From: [Downes, Scott G \(DFW\)](#)
To: [Jeremiah Cromie](#)
Cc: [Torrey, Elizabeth M \(DFW\)](#); [Bates, Hannah \(DFW\)](#); [Morrison, Shaun \(DFW\)](#)
Subject: RE: LP-23-00002 Tumbling Ridge - Notice of Application WDFW Comments
Date: Thursday, June 1, 2023 2:19:05 PM

WDFW Land and Road Easement

Cle Elum River Corridor

TUMBLING RIDGE PRELIMINARY PLAT

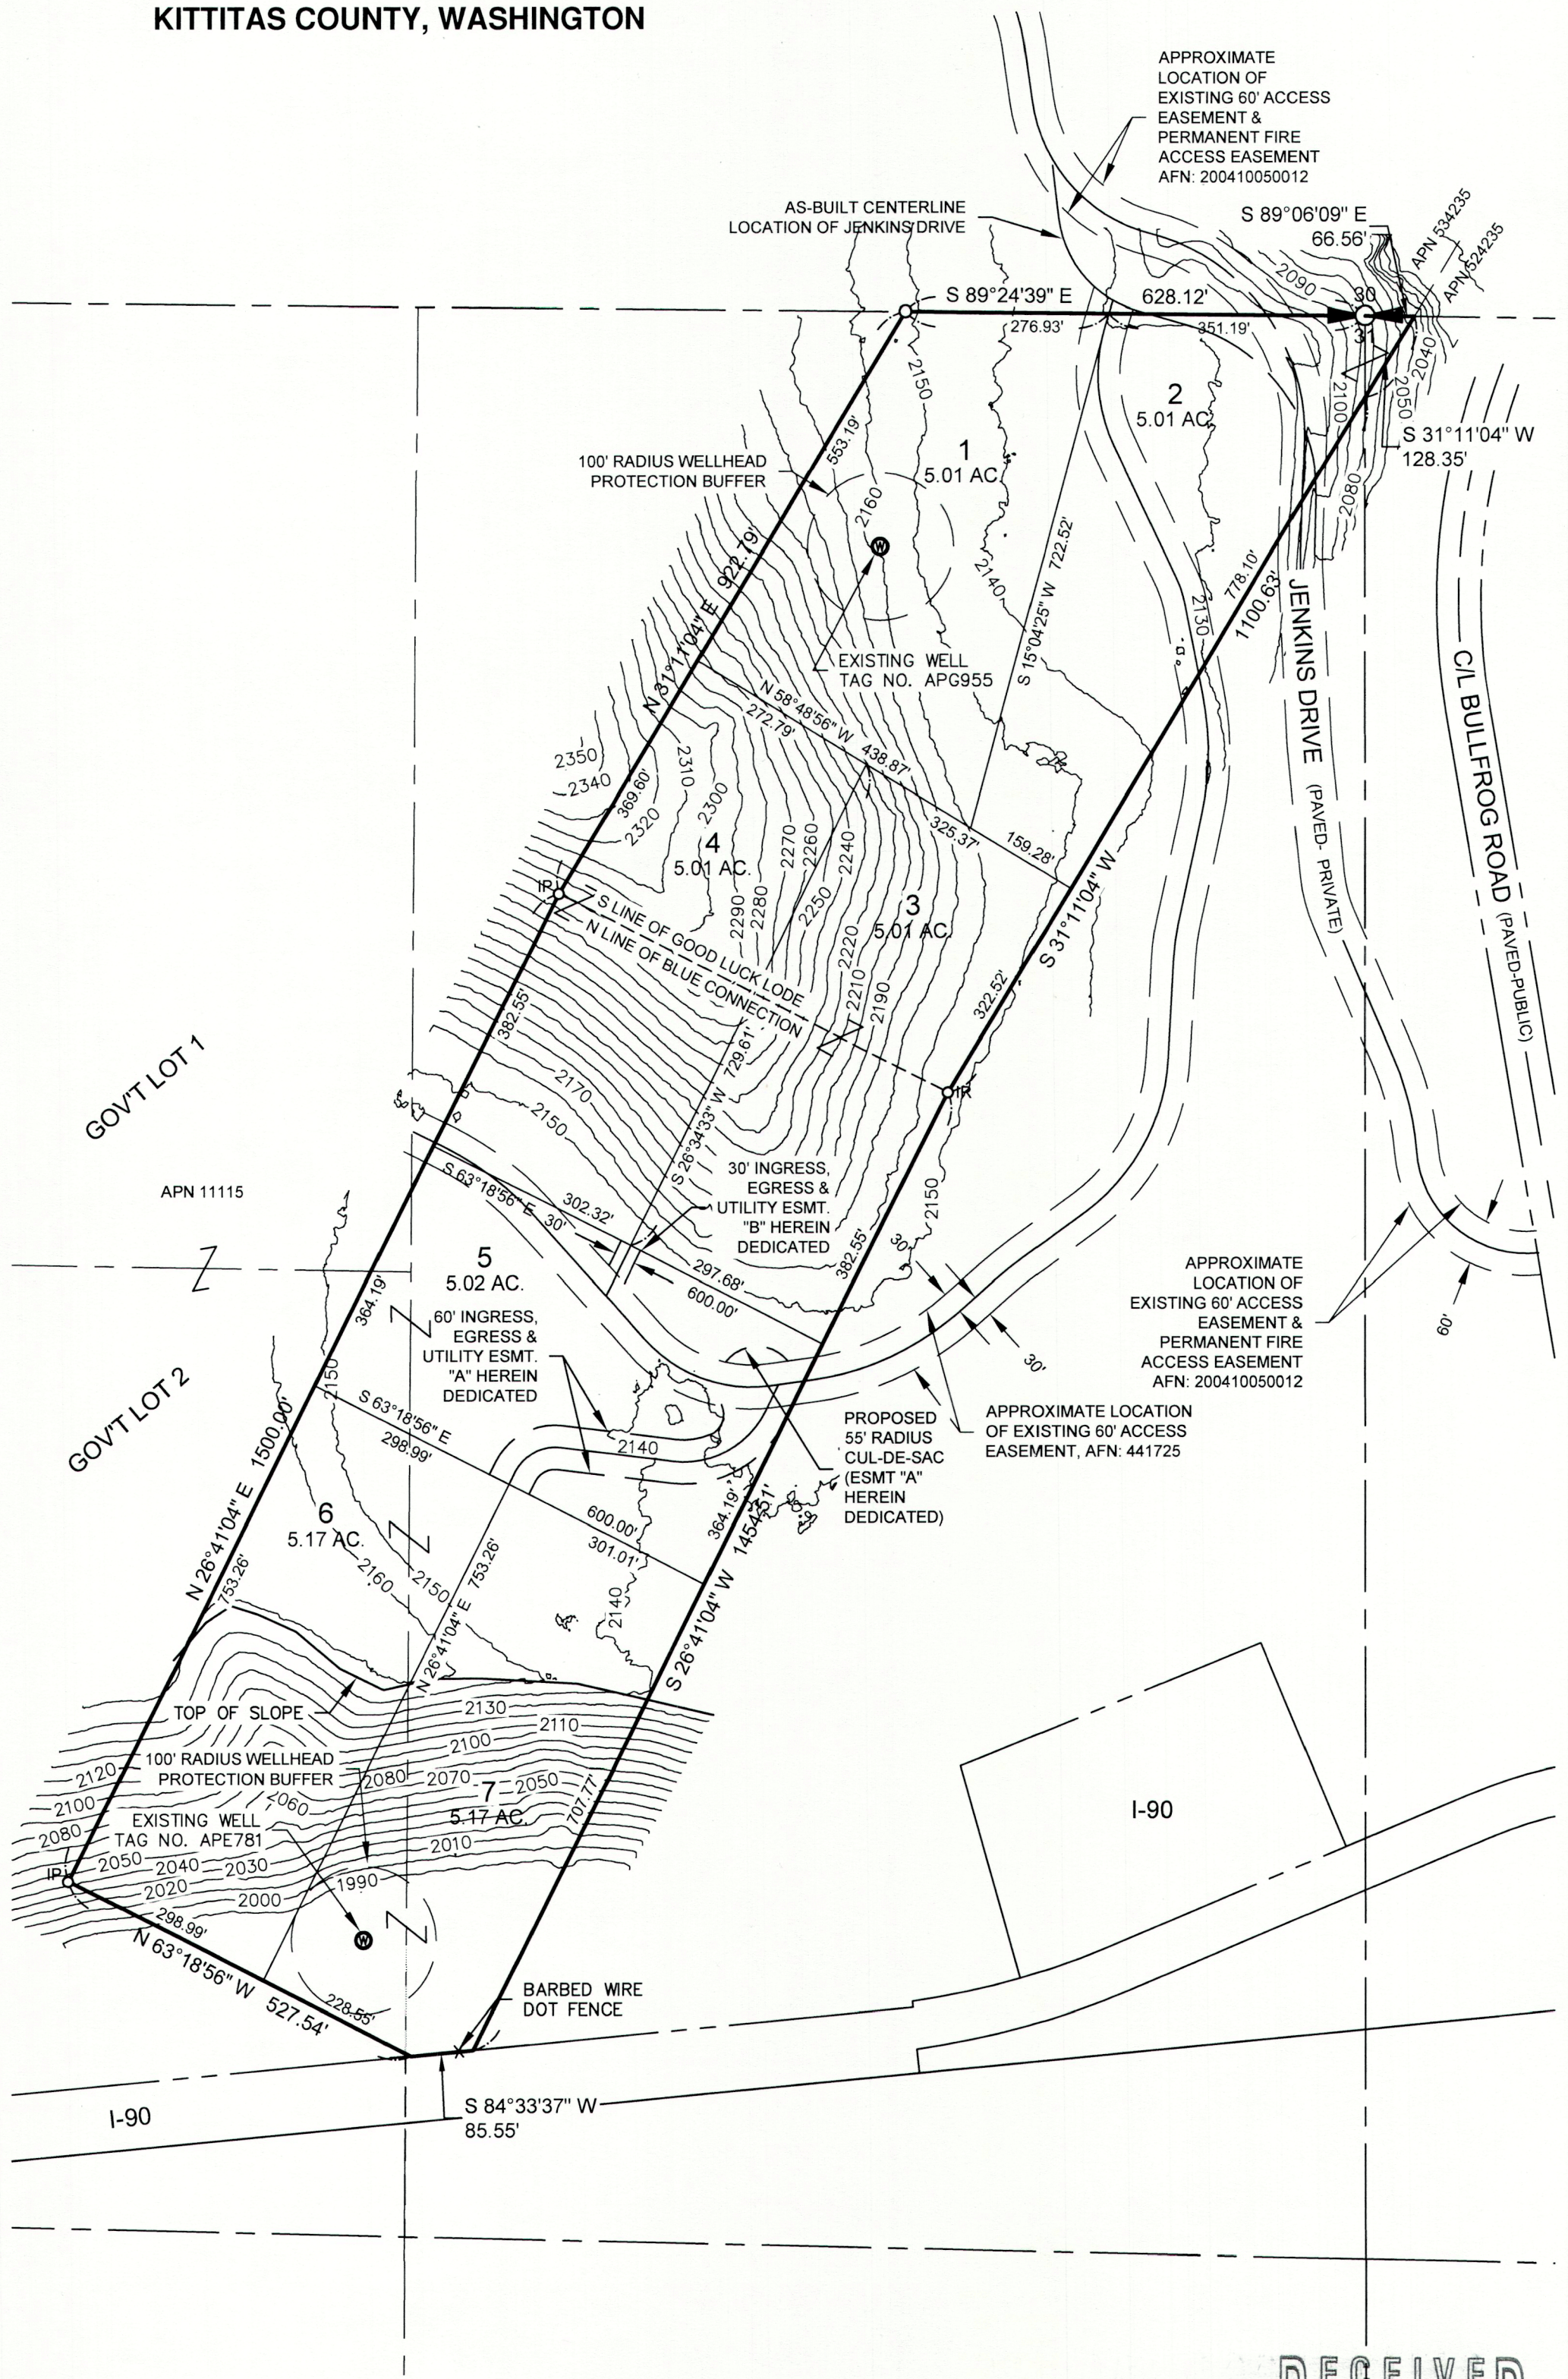
There is a road that passes through this plat to access WDFW lands to the west, namely proposed Lots 4 and 5. WDFW needs to maintain access along this road if the parcel is split and the residents need to be aware that they are living next to public land and the responsibility that entails. If this plat is approved, please work with the LT Murray manager Shaun Morrison to ensure that access is maintained for WDFW management of our land.

WDFW has concerns about the approval of Lot 2. The northern half of Lot 2 is situated above the Cle Elum River an important waterbody for aquatic life. Steep slopes in the northern half of this parcel could lead to landslides entering the Cle Elum River if proper precautionary measures are not taken. WDFW requests that if this Long Plat is approved, a Geotechnical report be required before any land clearing activities including tree removal is approved on the northern half of proposed Lot 2. The Geotechnical report should demonstrate where ground clearing could occur without causing disturbance to the steep slopes and increasing the risk of a landslide.
